**From:** Eisenberg, Jame J.  
**Sent:** Friday, June 12, 2015 2:46 PM  
**To:** Daggett, Kevin  
**Cc:** Harmon Rita T.  
**Subject:** RE: Amole Del Norte Detention Pond [Amole Del Norte Dam (OSE File No. D-577)]

The Grading and Drainage Plan and report for Paradise RV Park Phase II has been submitted. This site is just north of the Amole Del Norte Detention Pond. Roland Penttila had originally reviewed this plan in August, 2011 and felt it was acceptable. The developer has just recently resubmitted a revised plan, but this plan proposes 2 outfalls into the pond. With 2 outfalls, as opposed to the original single outfall, will this new plan still be acceptable? The engineer is willing to go back to 1 outfall if absolutely necessary.

**From:** Harmon Rita T.  
**Sent:** Friday, July 24, 2015 3:23 PM  
**To:** [ron@thegroup.cc](mailto:ron@thegroup.cc)  
**Cc:** Biazar, Shahab  
**Subject:** Paradise RV Park

SURVEY INFORMATION		BENCH MARKS		AS BUILT INFORMATION			
NO.	FIELD NOTES	DATE	CONTRACTOR	STAMPED	DATE		
	BY					STAKED BY	DATE
						INSPECTOR'S	DATE
						FIELD	DATE
						VERIFICATION BY	DATE
			MICRO-FILM INFORMATION				
			DA--001703.21"		DATE		
			ELEVATION, IN FEET (NAVD88) = 5250.166		NO.

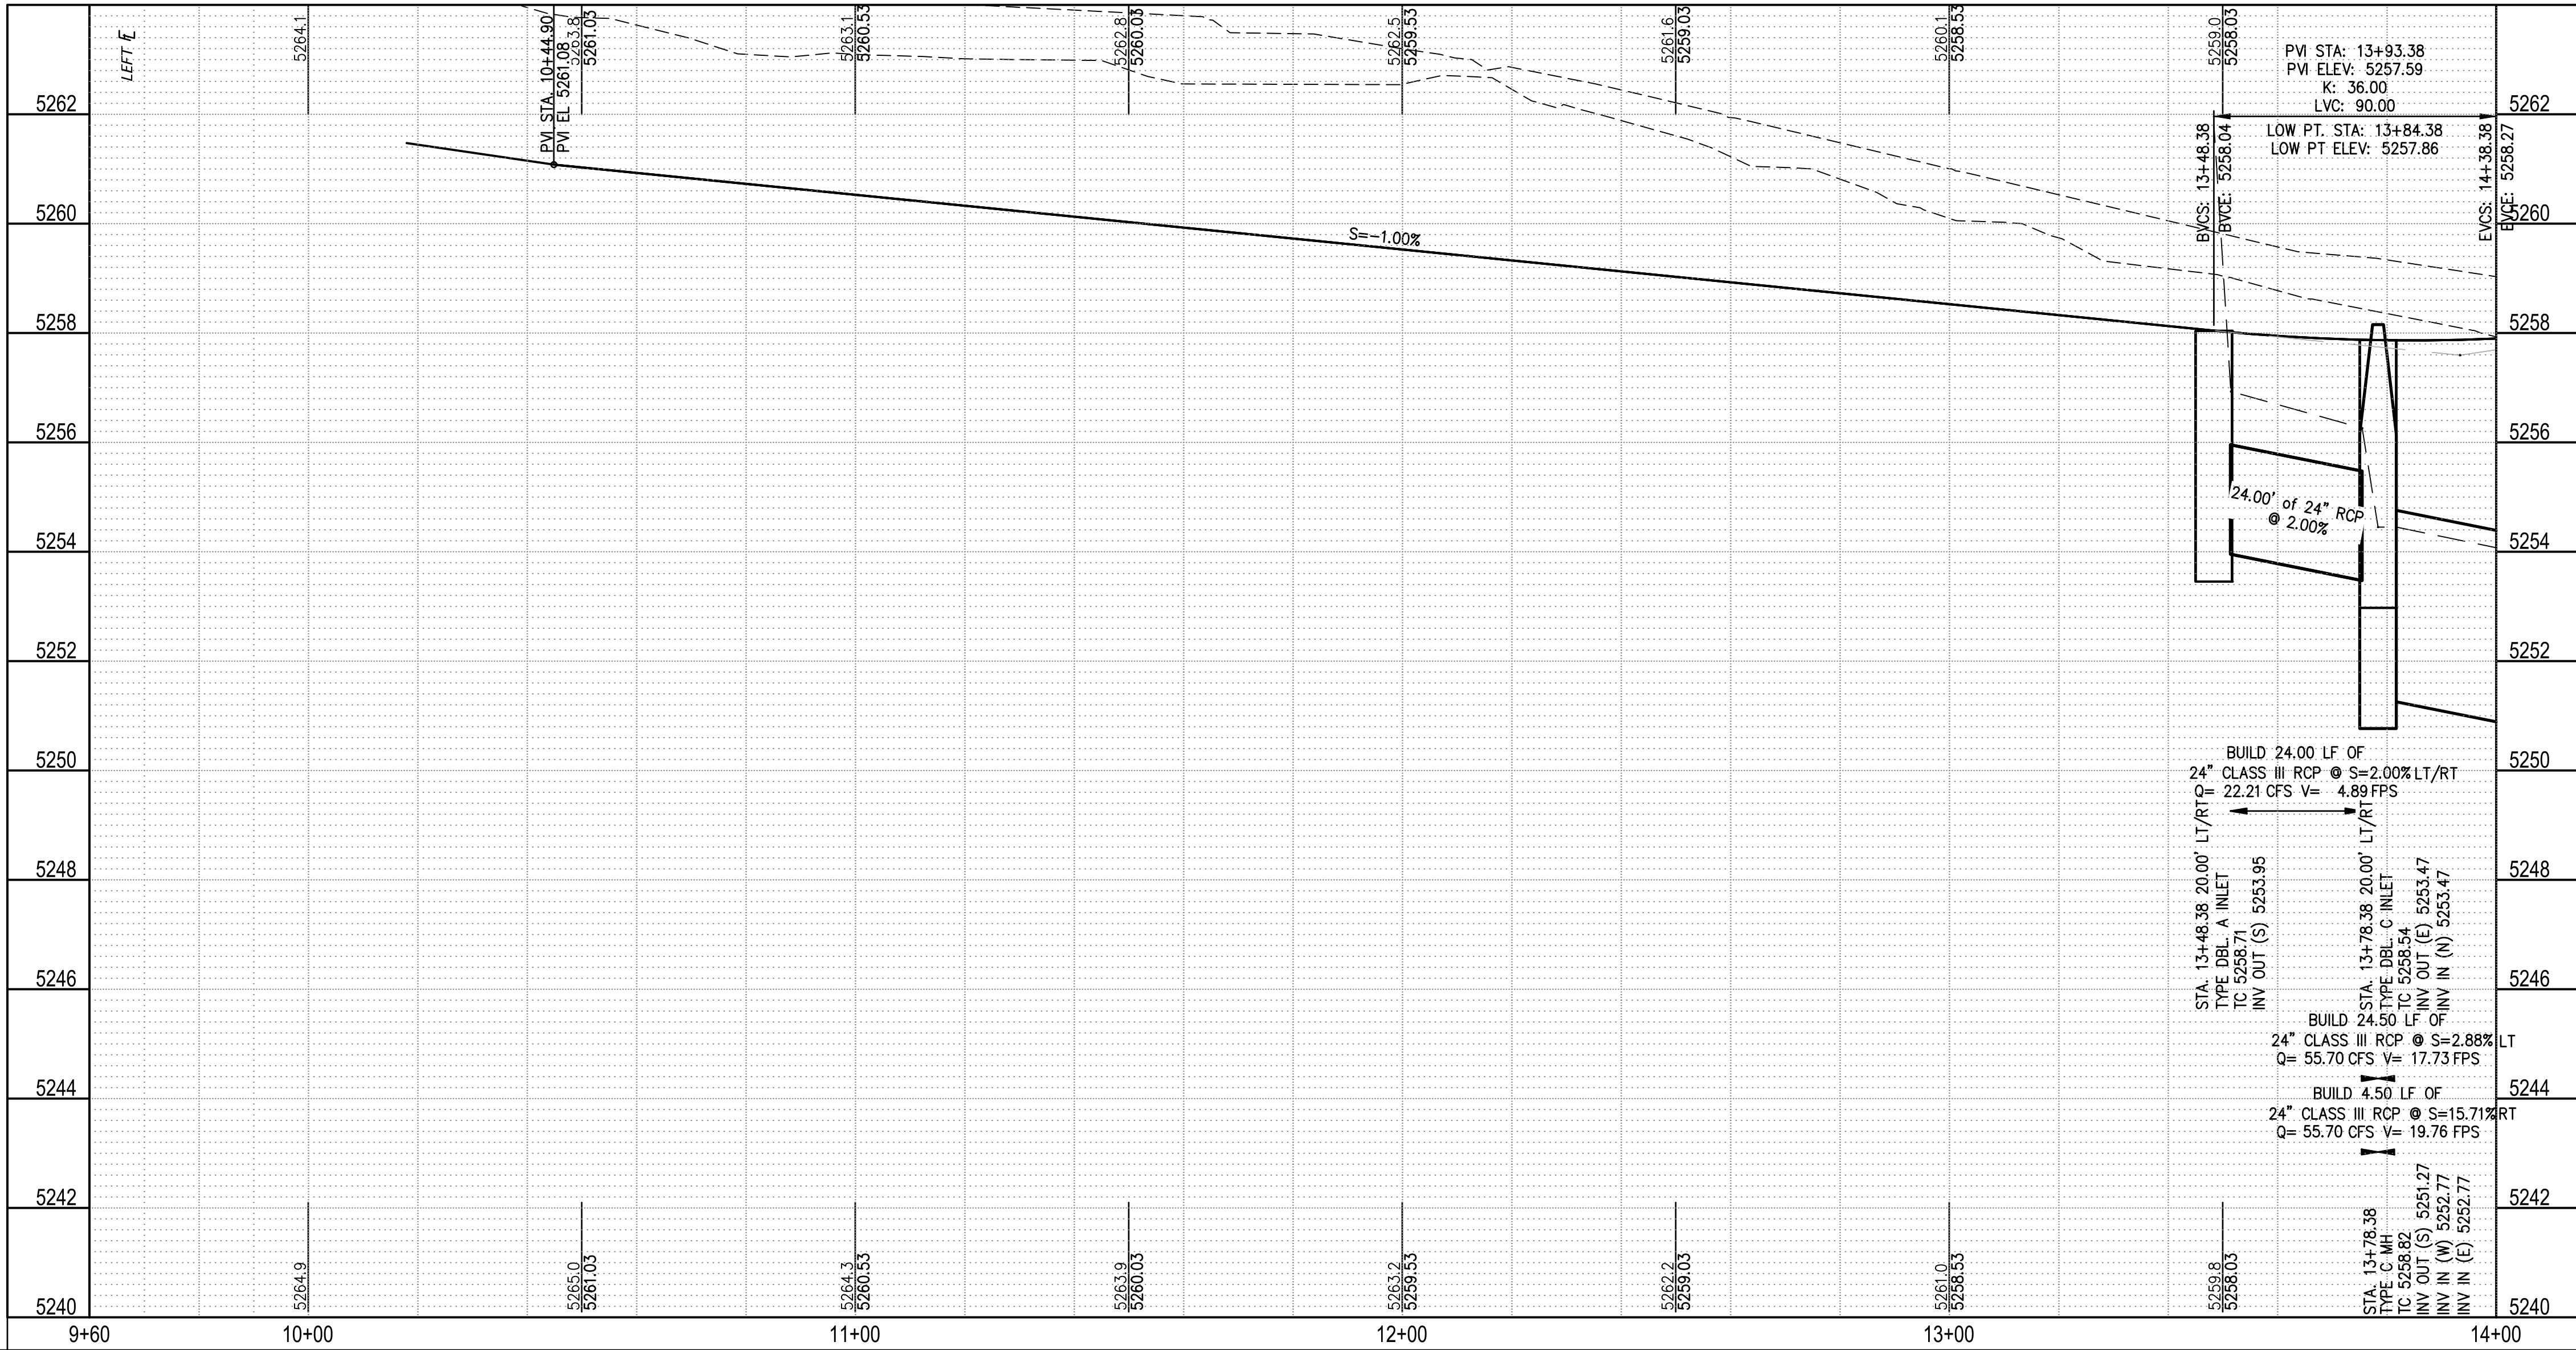
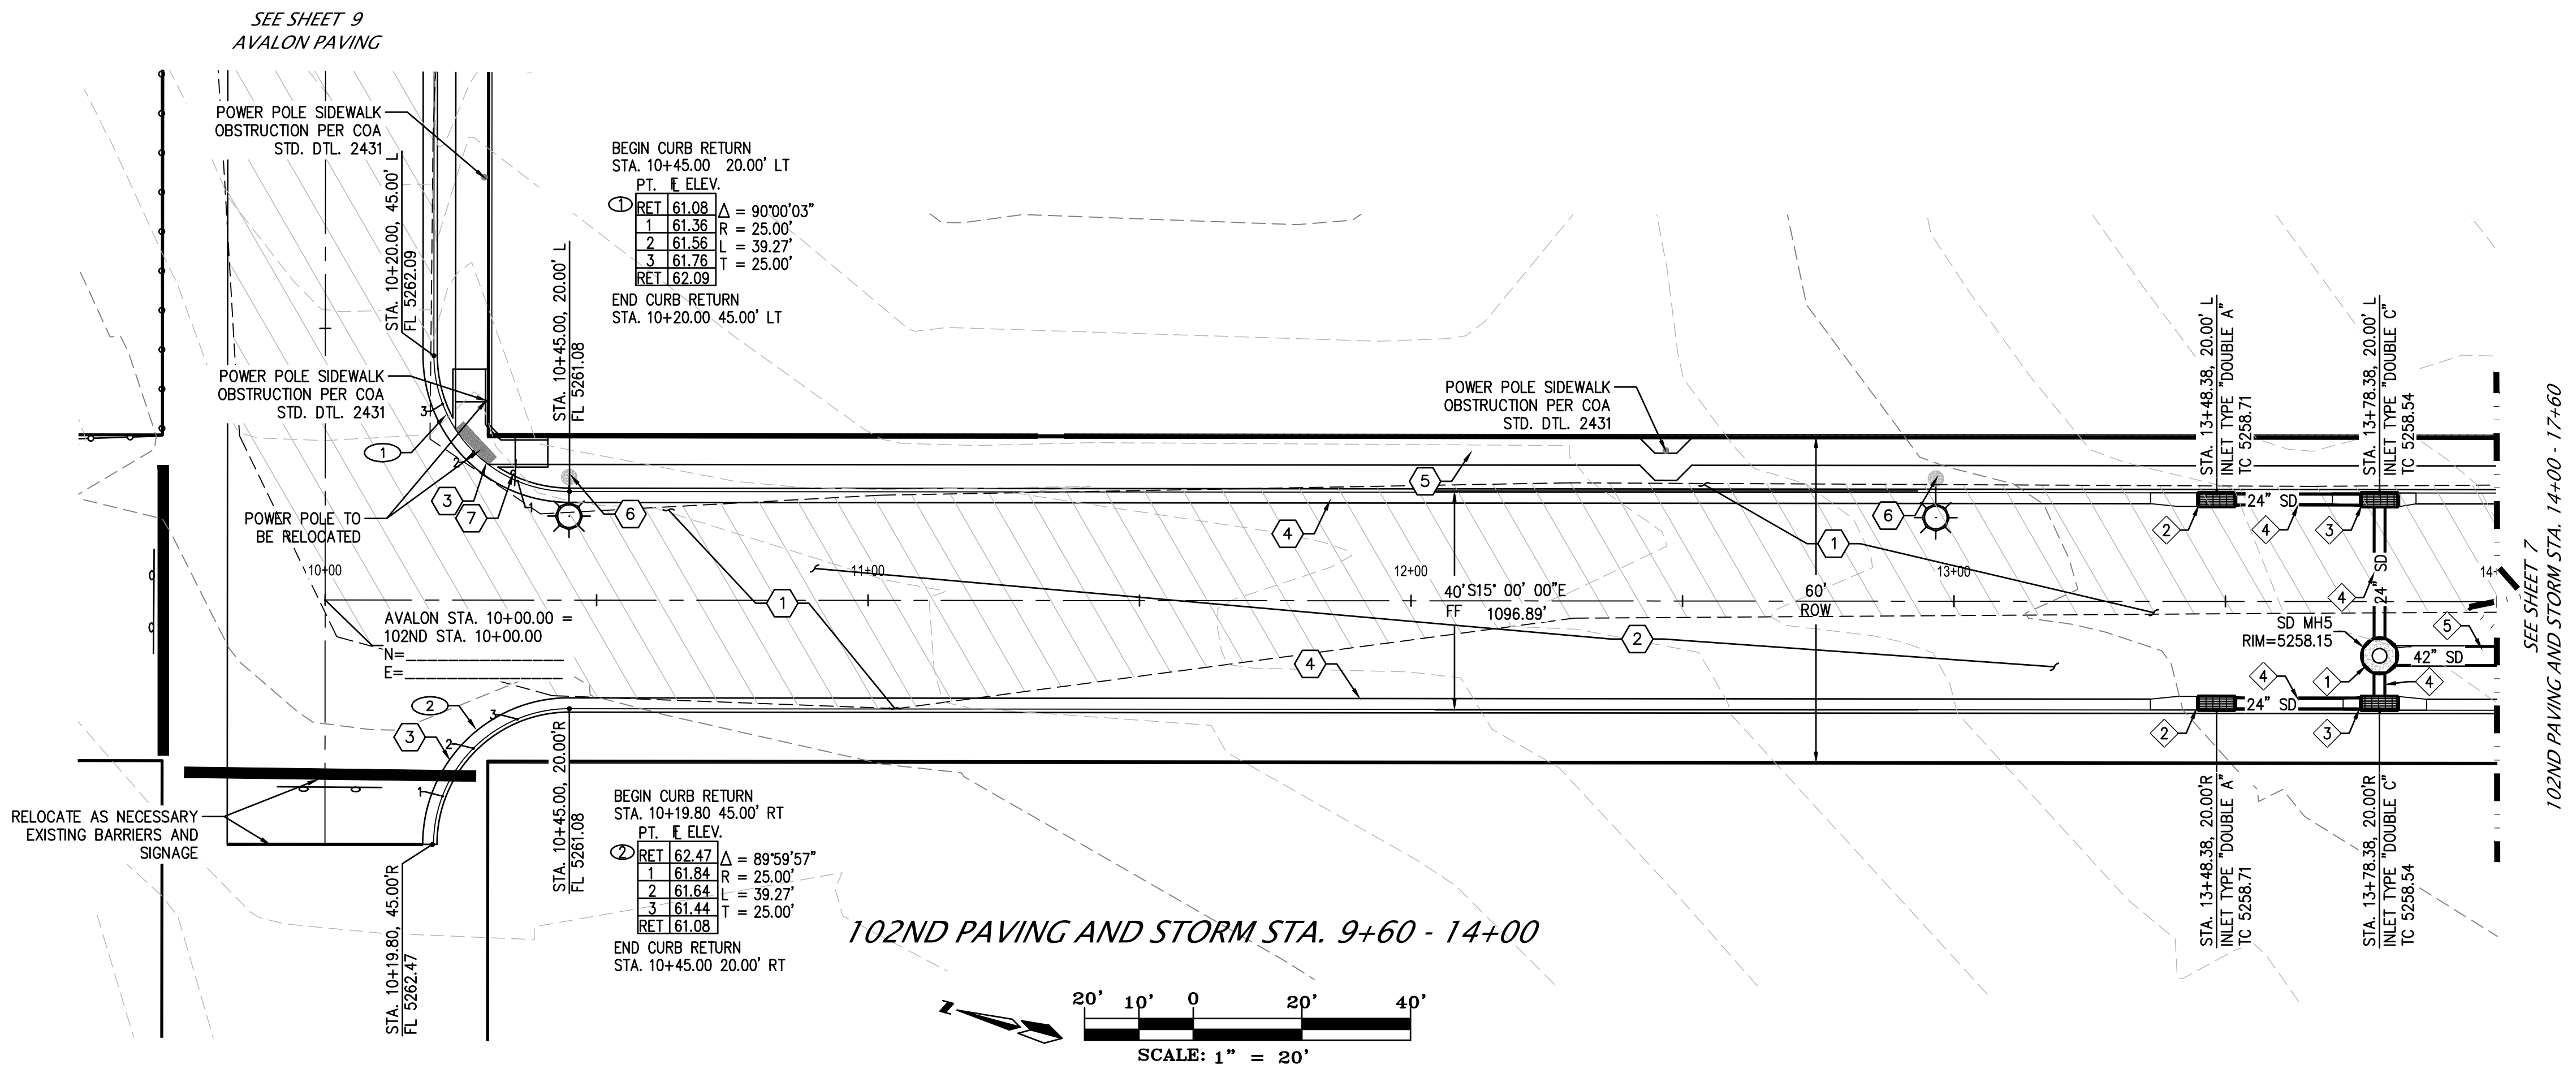
- a. Cut Basin 205.1 in half along 106<sup>th</sup> St. and route western half to Basin 204.1. Reason being that the 84" SD to S. Pond was sized for 334cfs. With all of Basin 205.1 discharging to SD in 98<sup>th</sup> St, the peak flow is 361 cfs- may be too high. Note: With half of Basin 205.1 being routed to the 72" storm drain in Volcano, the pipe may need to be upsized.

- b. AHYMO needs to be rerun with the Basins immediately west of 98<sup>th</sup> Street being routed to the South Pond. They are being added to flows in Volcano SD and then routed to N. Pond (see AHYMO summary). They should be routed directly to the S.Pond.

- i. This may change the analysis for the 102" SD, since 361 cfs being re-routed.

- ii. What is the HGL in the 72" with this change? We may be able to leave as 72" rather than upsize.
  - c. Use the Staged discharge Curve using the Tierra Bayita III 1998 Report as it included the access road.

- 7) The outfall of this site into the Dam needs further discussion. I am asking DMD for clarification of whether or not a SD can outfall into the Dam, or did they prefer a concrete rundown. They do want a v-ditch/channel on the south side of Volcano Road to direct offsite flows into the Dam, and also for the Concrete Rundown to be modified as needed.

I need a little clarification: Was it ok for the developer to discharge his site into the Dam using an underground SD? He cannot use a rundown since the SD from his site is at 5222 and the top of the Dam is at 5230.

Ron,  
You can discharge into the pond via Storm drain as opposed to a rundown.

I'd like to change my response regarding this question. 19.25.12.19 NMAC requires that approval must be received from the state engineer to reconstruct, enlarge, modify, restore reservoir capacity, repair, remove or breach an existing dam. Based on internal discussion, we do not believe placing the inflow pipe deeper at the upstream end of the reservoir would be considered a modification to the dam, requiring coordination with the DSB, since it is not impacting the dam embankment or changing the inflow (inflow to the reservoir was anticipated to be pipe flow for the fully developed watershed).
